Our Ref: FP/139/19/OUT
Your Ref:

Town & Country Planning Act 1990 (as amended)
Town & country Planning (Development Management Procedure) (England) Order 2015 - Article
5
Application for Outline Consent

Development Outline application with all matters reserved for the erection of 1 No. dwelling.
Location Land south of garage compound & East of 12 Alfriston Close Felpham

Site Location Plan

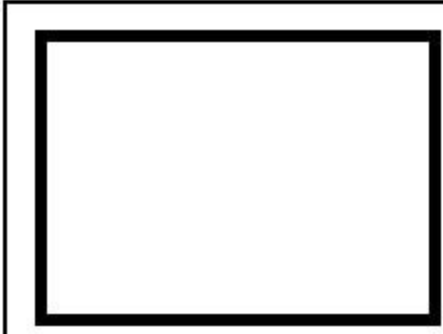
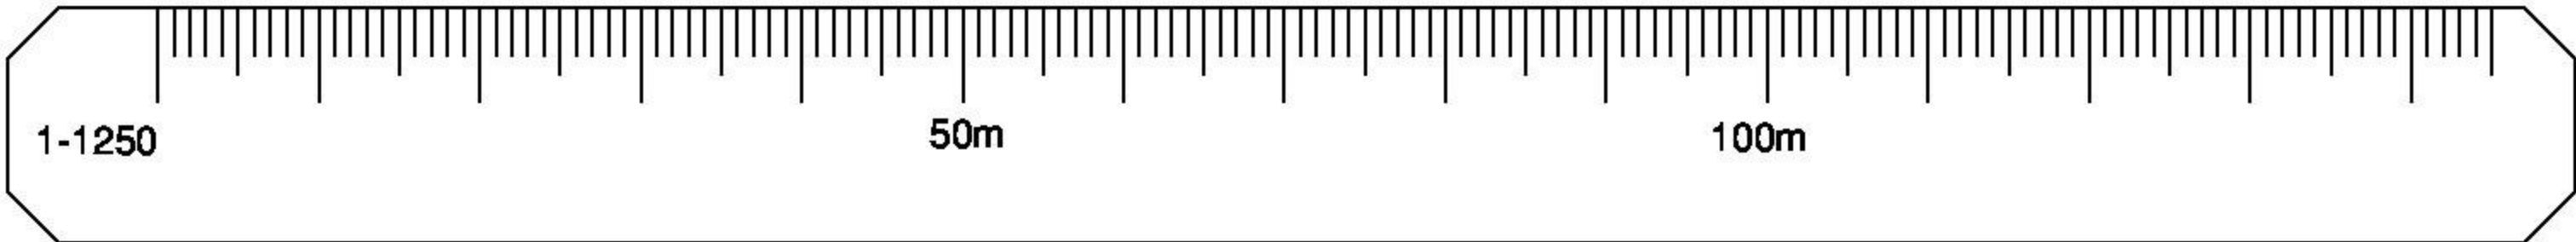
Location Plan Amend

Please clearly show the proposed access within the red edge.

Please confirm the amended site address is an accurate reflection of the location of the site.
